6 November 2020

**Kings Park Metal Recovery and Recycling Facility Expansion (SSD-10396)  
Request for Additional Information**

## ATTACHMENT 1

Figure 2 – Site, noise monitoring and receiver locations

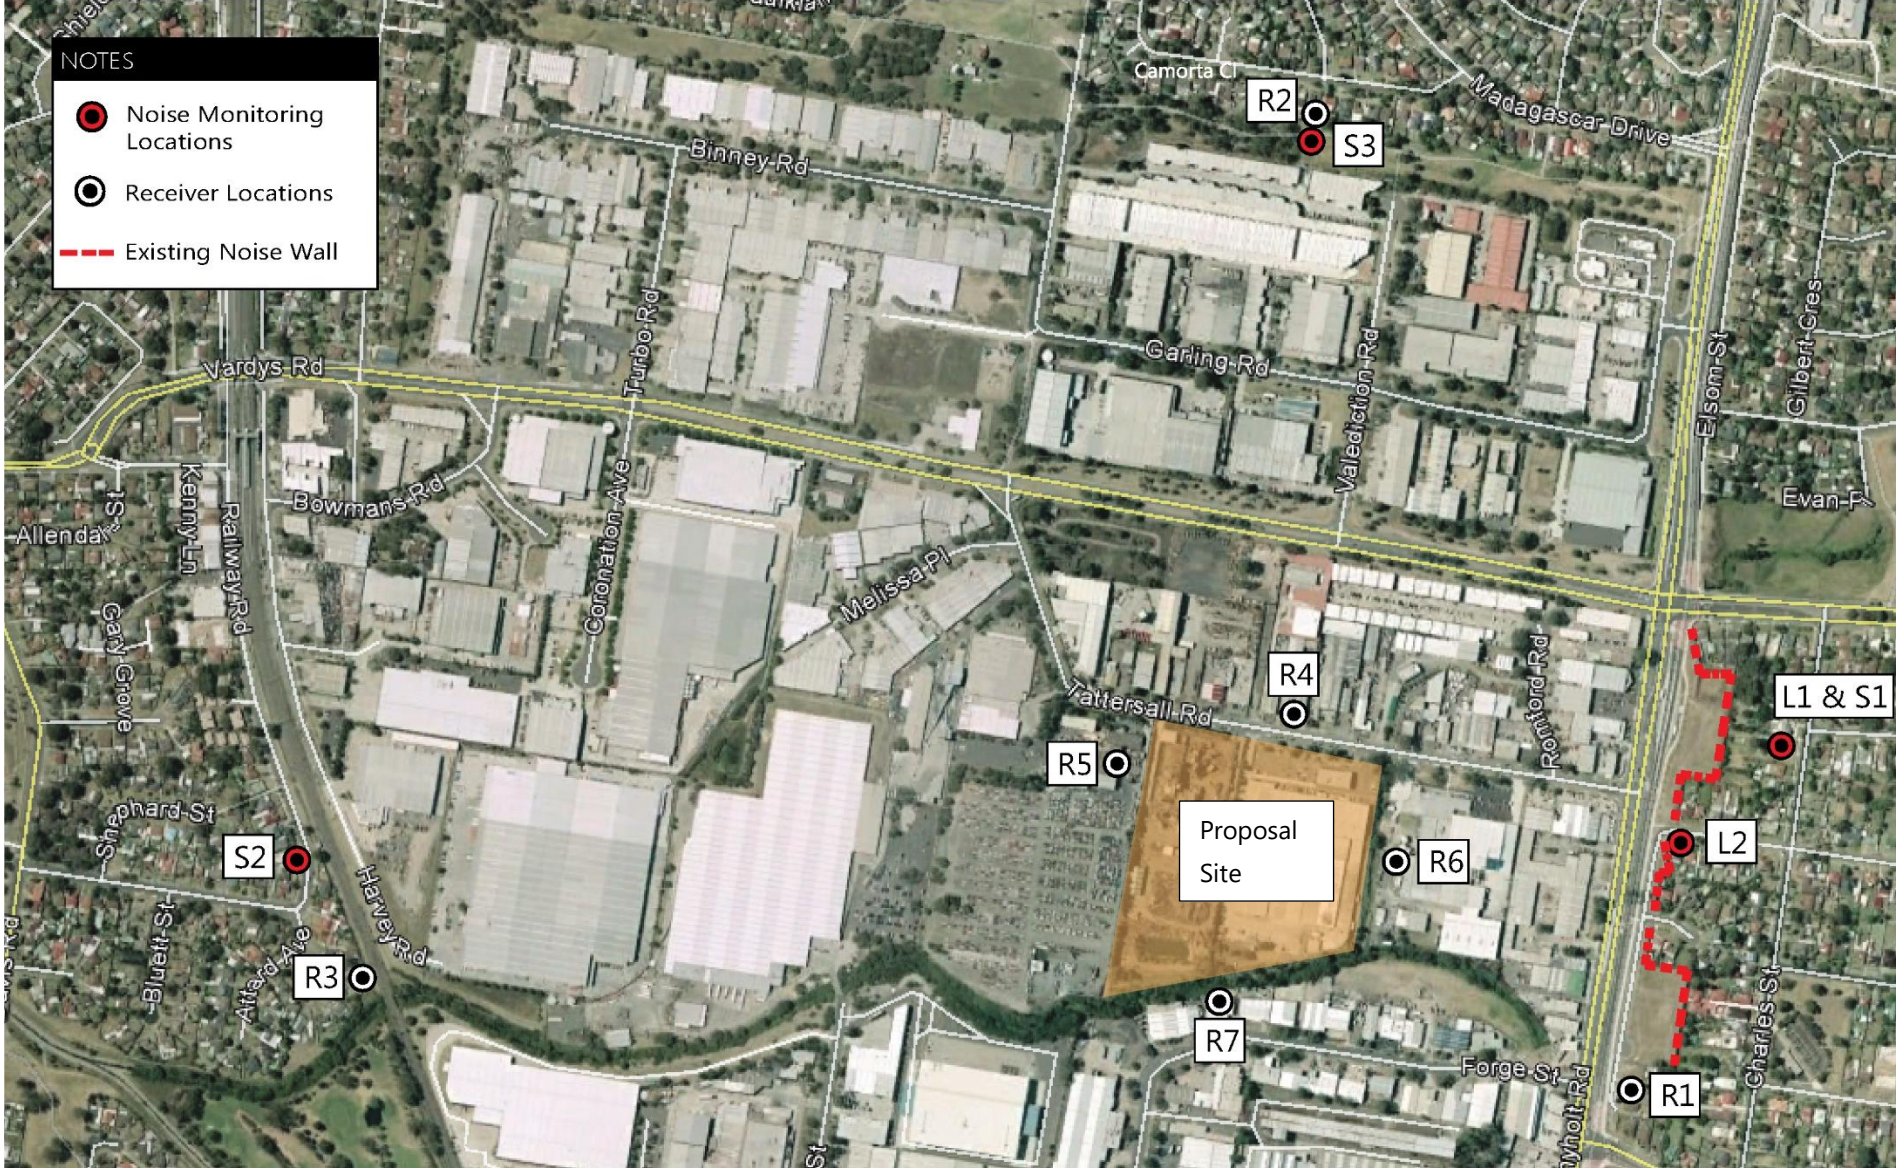
- NVIA appears to only have presented predicted operational noise levels at one (1) receiver location due east of the site, it is not clear if Location R1 is indeed the most-affected location in the Blacktown catchment area. Please provide noise contours showing the range of predicted operational noise levels for residential receivers from Sunnyholt Road to the highest location above sea level along Anthony Street, covering an assessment radius of around 700 metres from the eastern site boundary.

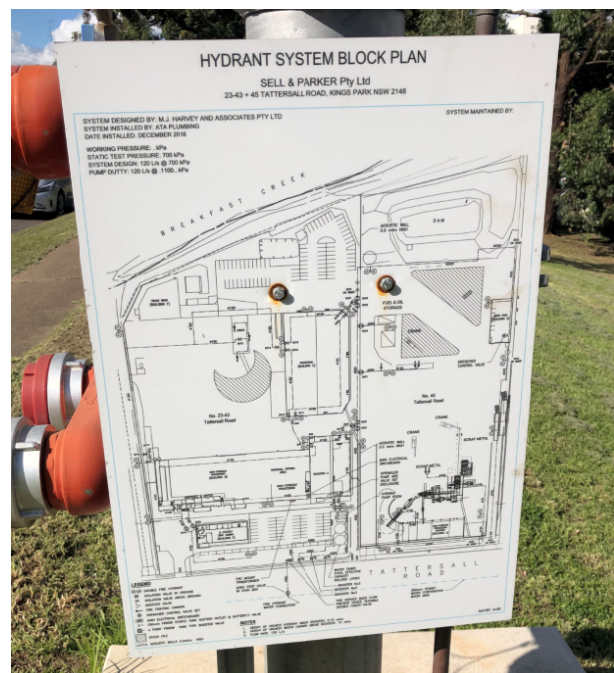
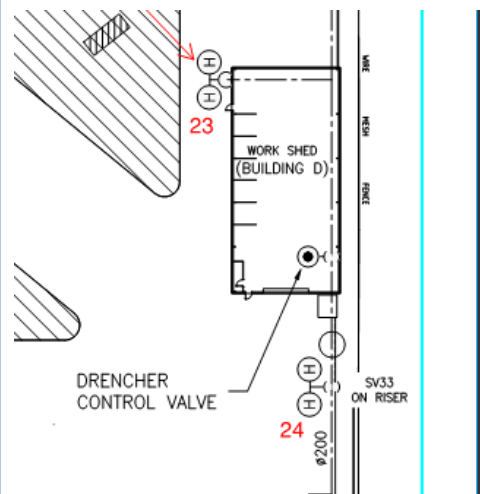
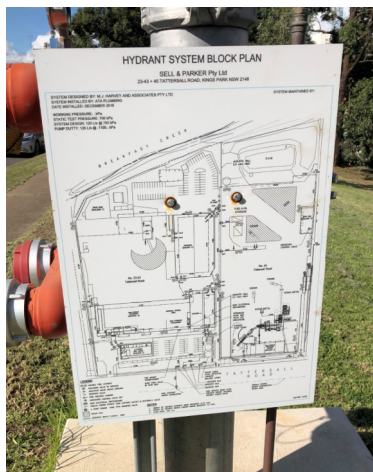
- The fire hydrant report in Appendix K identified numerous non-compliances. However, the EIS states 'The Fire Hydrant Assessment (Appendix K) identified that the existing fire infrastructure on-site would be able to adequately manage fire risks associated with the Proposal without additional alterations'. Please clarify when and how the non-compliances have been or will be addressed.

Figure 3 Available stacking spaces

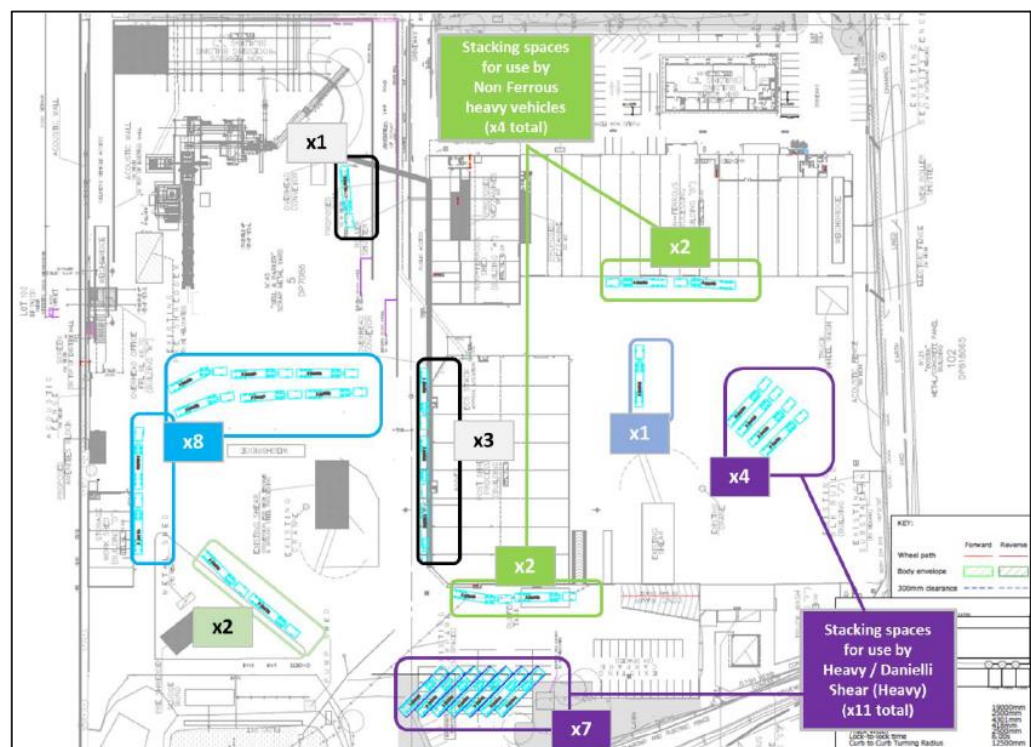
- NearMaps shows that a number of skip bins and truck trays are located to the south of the post shredder processing building, in the location of a number of the proposed stacking spaces and as such within proposed paths of vehicles. Please clarify the purpose of these skip bins and truck trays and whether they will be moved prior to the commencement of any expanded operations and if so, where will they be moved to?

Figure 5 Operational areas and location of plant and equipment

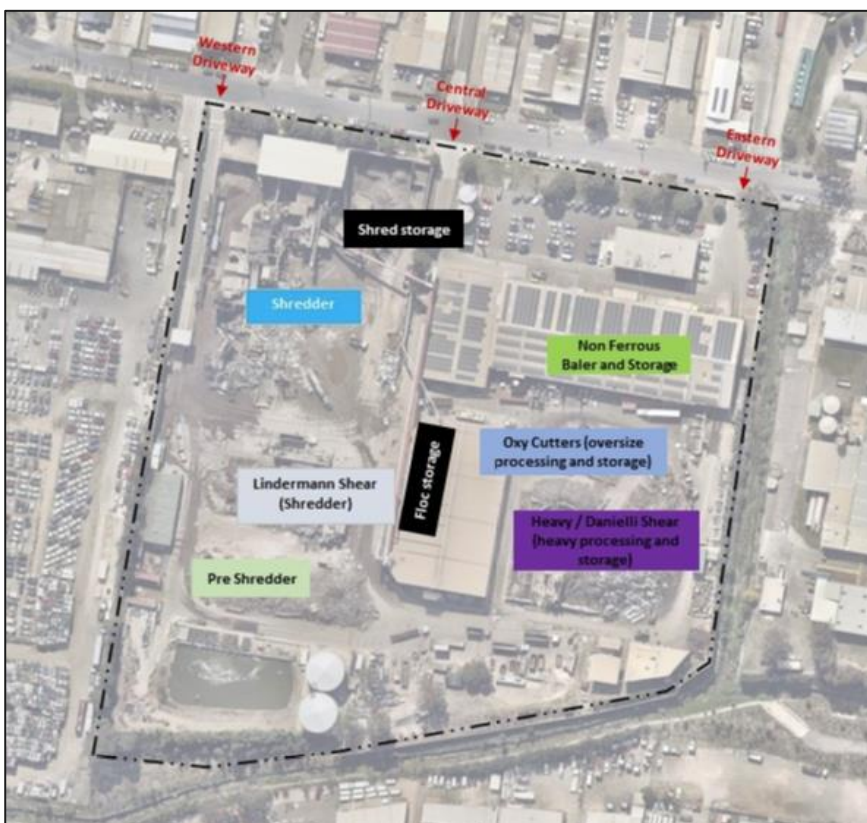
- Please clarify the use of Building A, as Table 2-2 and Figure 2-3 label it as maintenance workshop and non-ferrous shed respectively.
- It is noted that on the site plan the north-western corner of the site contains Building L, a metal awning and 'machinery'. Please clarify what machinery is present at that location.

- Please show and label all plant, including those in buildings, on the site plan.
